May 18, 2020

Re: Maverik Gas Station
3601 Montgomery Blvd NE
Traffic Circulation Layout
Engineer's Stamp 05-12-2020 (F16-D001A)

Based upon the information provided in your submittal received 05-15-2020, the above referenced plan cannot be approved for Building Permit until the following comments are addressed:

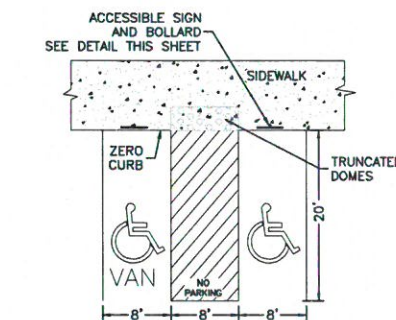
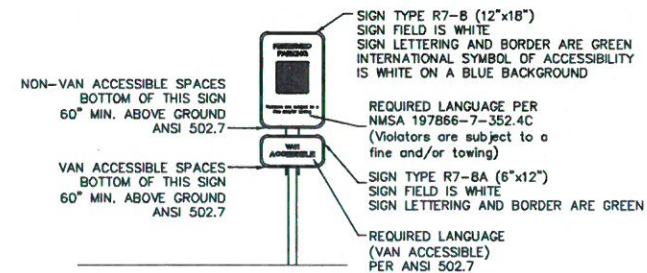
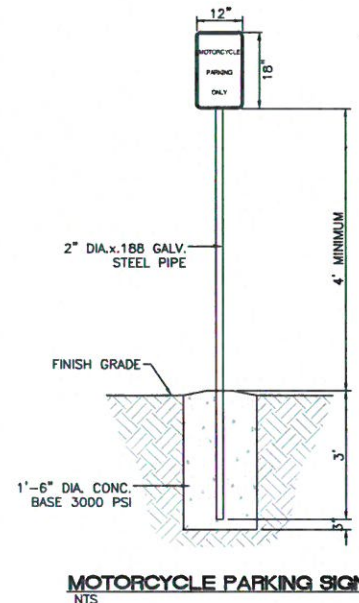
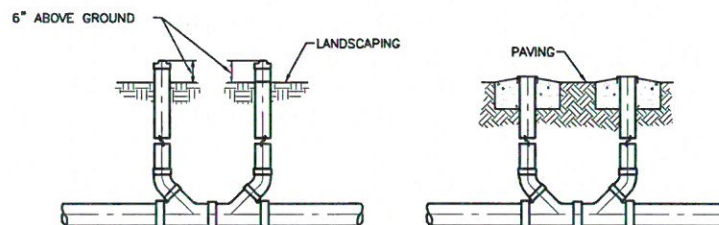
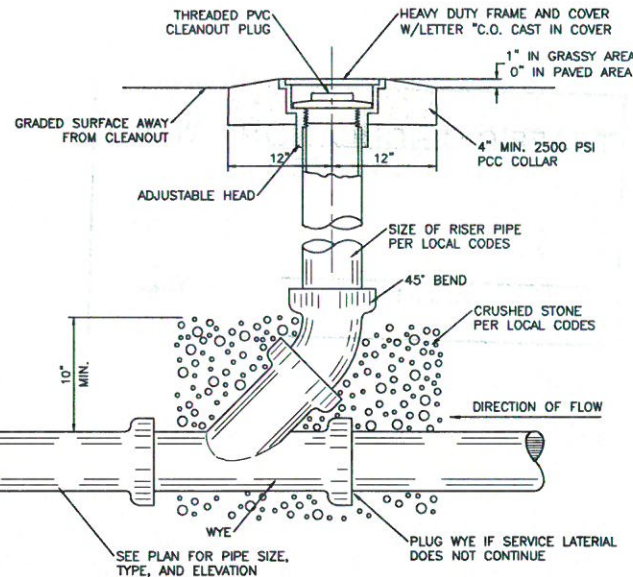
- a. The rack shall be a minimum 30 inches tall and 18 inches wide.
 - b. The bicycle frame shall be supported horizontally at two or more places. Comb/toaster racks are not allowed.

- c. The rack shall be designed to support the bicycle in an upright position. See the IDO for additional information.
 - d. The rack allows varying bicycle frame sizes and styles to be attached.

- e. The user is not required to lift the bicycle onto the bicycle rack.
 - f. Each bicycle parking space is accessible without moving another bicycle.

12. Bicycle racks shall be sturdy and anchored to a concrete pad.
13. A 1-foot clear zone around the bicycle parking stall shall be provided.
14. Bicycle parking spaces shall be at least 6 feet long and 2 feet wide.

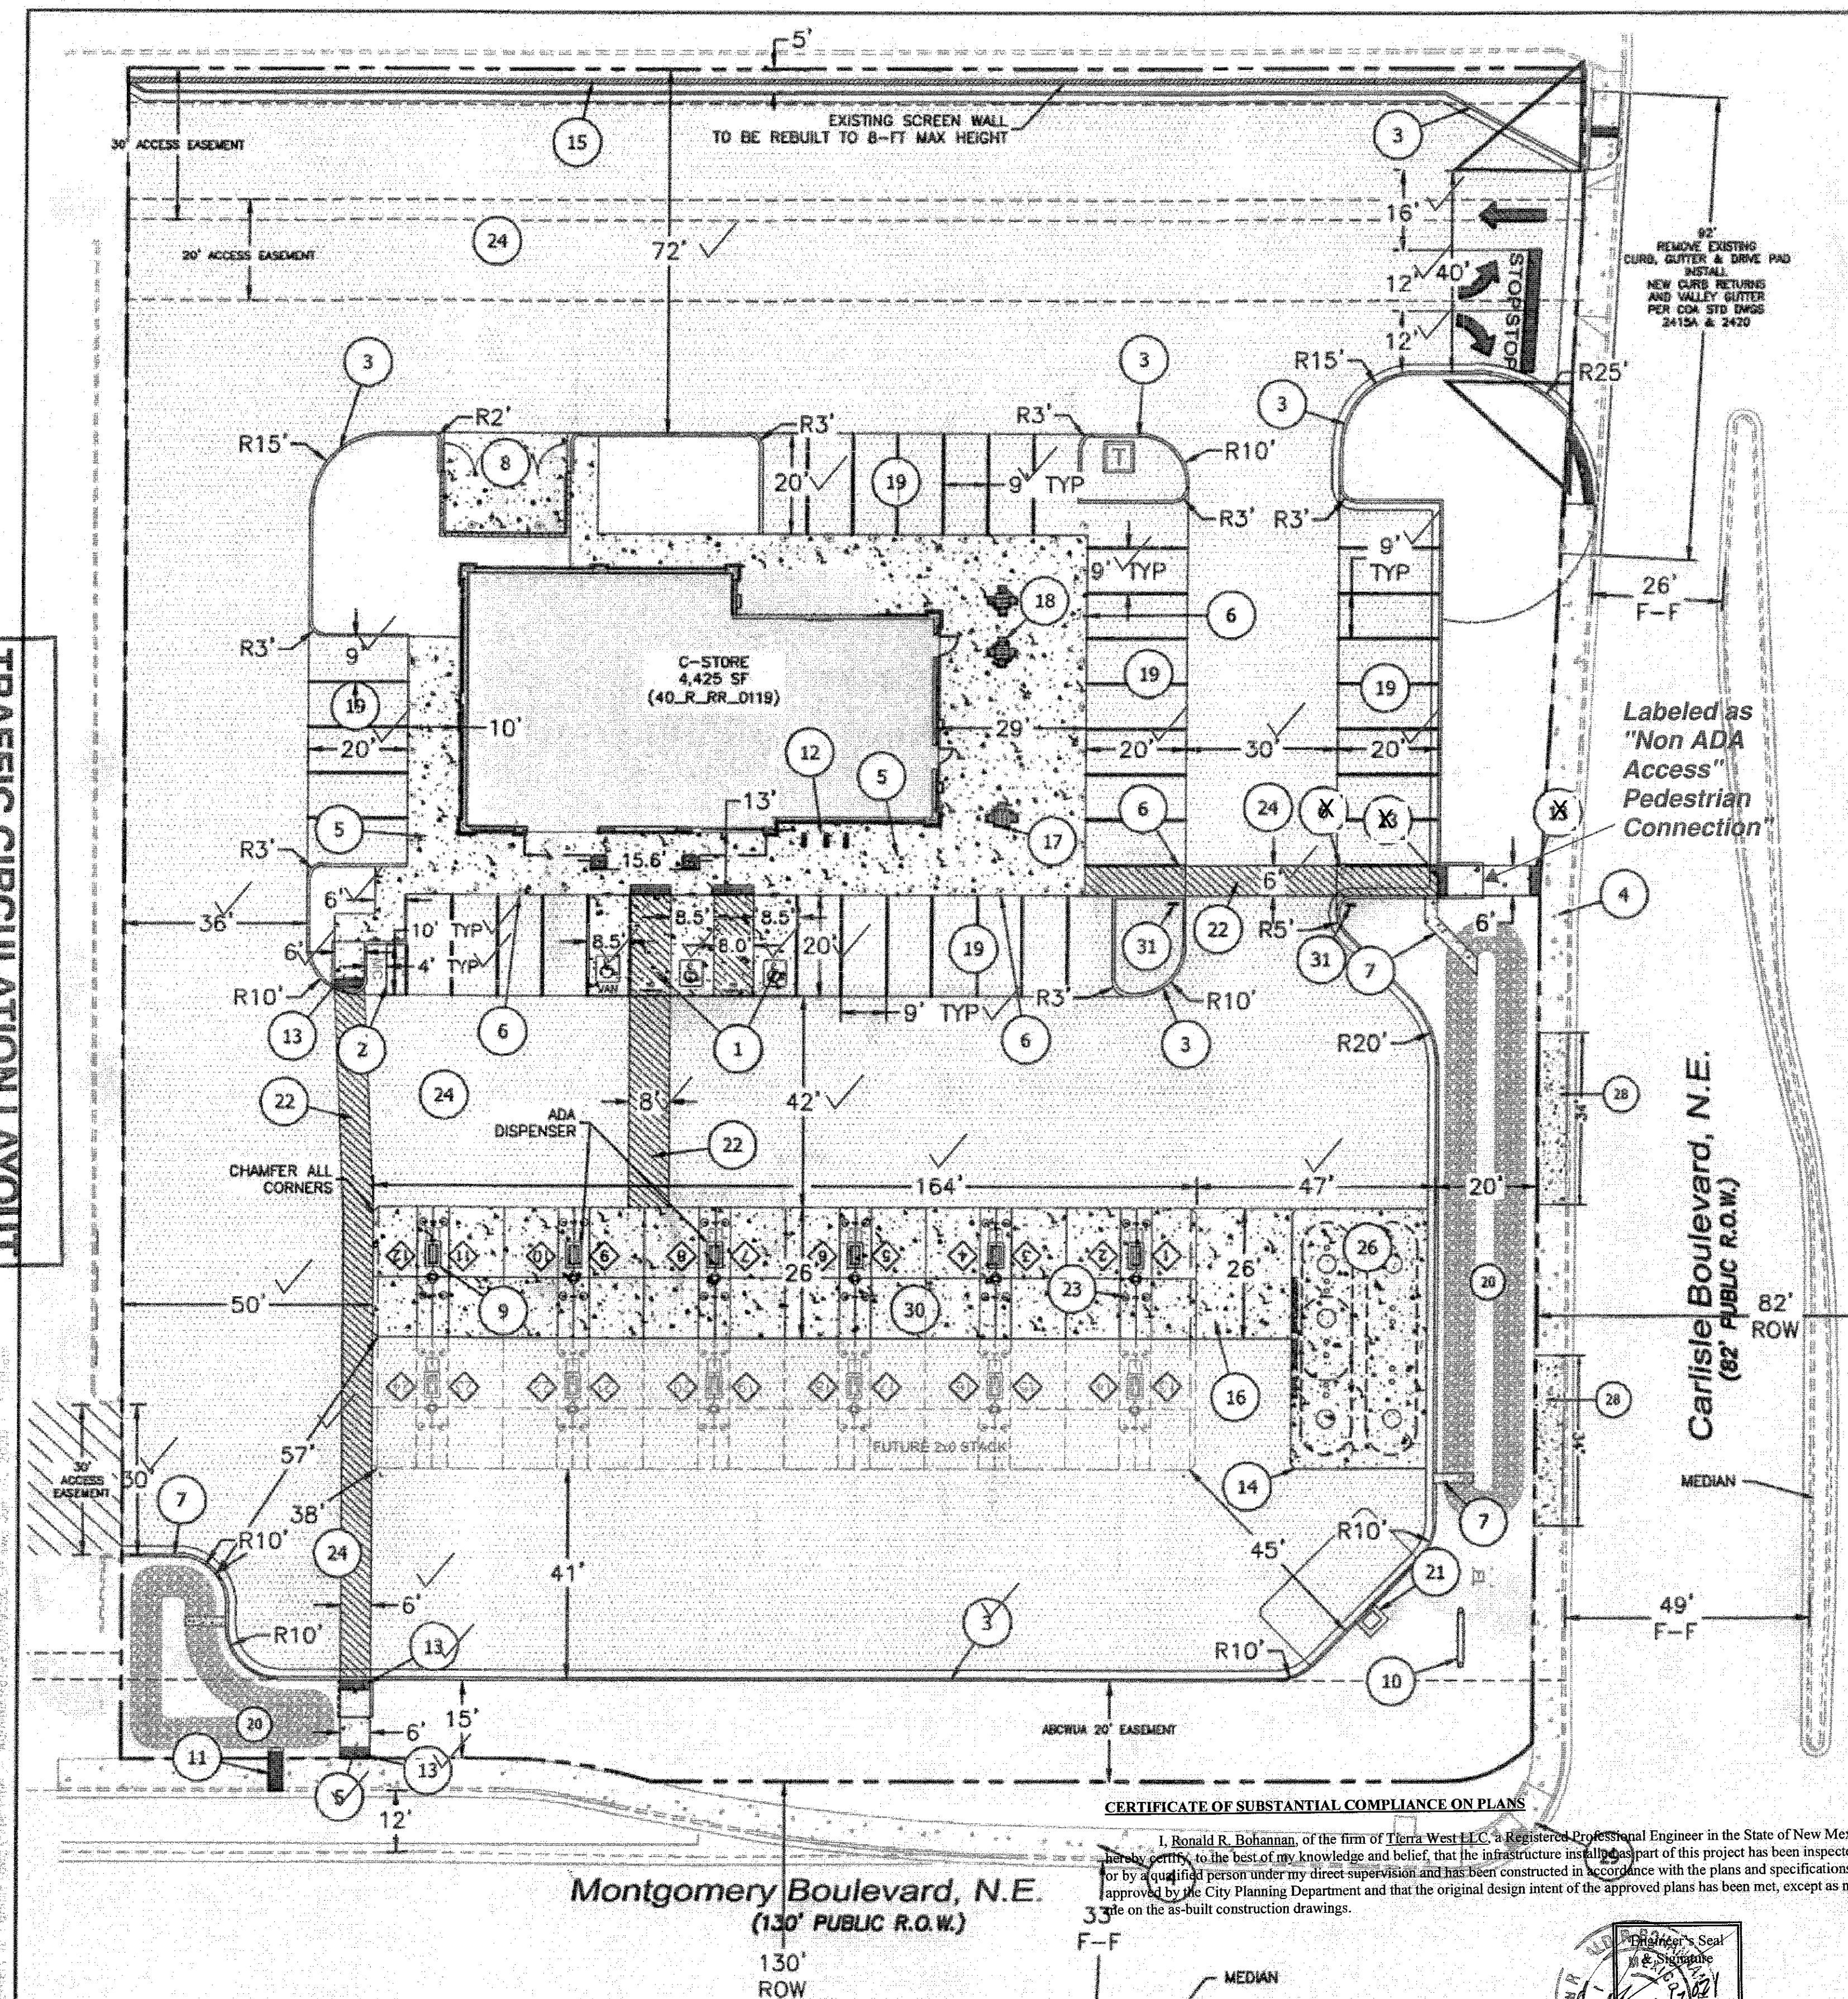
1. Please coordinate all calculations for parking spaces, including bicycle and motor cycle parking with Zoning and list the number required.
2. Property line off Carlisle doesn't match the AGIS location. Please verify that property line is correctly placed within Carlisle segment and no additional right-of-way dedication is needed.
3. All sheets need to be labeled Traffic Circulation Layout Plan and not Traffic Control (sheets C1 & VT-1).
4. Identify the right of way width, medians, curb cuts, and **street widths** on Montgomery and Carlisle.
5. North side of Carlisle entrance: the proposed sidewalk, C&G and ADA needs to begin at property line.
6. The minimum parking stall dimensions are:

7. Dimension motorcycle parking stalls.
8. ADA parking stall signs are in conflict with vehicle overhang
9. The ADA access aisles shall have the words **"NO PARKING"** in capital letters, each of which shall be at least one foot high and at least two inches wide, placed

10. ADA curb ramps must be updated to current standards and have truncated domes installed at the corner of Montgomery and Carlisle.
11. All bicycle racks shall be designed according to the following guidelines (Add notes to detail sheet):

15. List radii for all curves shown; for passenger vehicles. Radius for delivery trucks, fire trucks, etc. is 25 ft. or larger (Explain if this is a concern since you have wide drive aisles).

16. Per the IDO, a 6 ft. wide ADA accessible pedestrian pathway is required from the public sidewalk to the building entrances. Please clearly show this pathway and provide details and label the proposed width.

17. Per DPM, a 6 ft. wide ADA accessible pedestrian pathway is required from the ADA parking stall access aisles to the building entrances. Please clearly show this pathway and provide details. Show how you will obtain 6 ft around the columns(what appear to be columns/path obstruction).

18. ADA accessible pedestrian pathway should not be placed between gas pumps and/or adjacent to a vehicular way. Vehicle and pedestrian/wheel chair conflicts should be avoided as much as possible. Your proposed pathway is in conflict with drive aisle between pumps and on the main line. Please address these safety concern. The proposed pedestrian pathway connection Carlisle will need signage and striping to define it's proposed crosswalk.

19. All sidewalks along streets should be placed at the property line.
20. Curbing should be installed to delineate landscape, parking, and pedestrian ways and identify points of access. Please call out detail and location of barrier curb.

21. Parking stall shall have barriers/bumpers to prevent vehicles from extending over sidewalk fronting building or will bollards serve the same proposed without conflicting vehicle overhang?
22. Provide a copy of refuse approval.
23. It is not apparent what type of pavement surface is being proposed. A hard driving surface will be required as part of this proposed project for parking area and drive aisles.

24. Please provide a sight distance exhibit (**See attachment** for example).
25. Show the clear sight triangle and add the following note to the plan:
"Landscaping and signage will not interfere with clear sight requirements. Therefore, signs, walls, trees, and shrubbery between 3 and 8 feet tall (as measured from the gutter pan) will not be acceptable in the clear sight triangle.
26. Please specify the City Standard Drawing Number when applicable.
27. Shared Site acces: driveways that straddle property lines, or are entirely on one property but are to be used by another property, shall have an access easement. Please include a copy of your shared access agreement with the adjacent property owner.
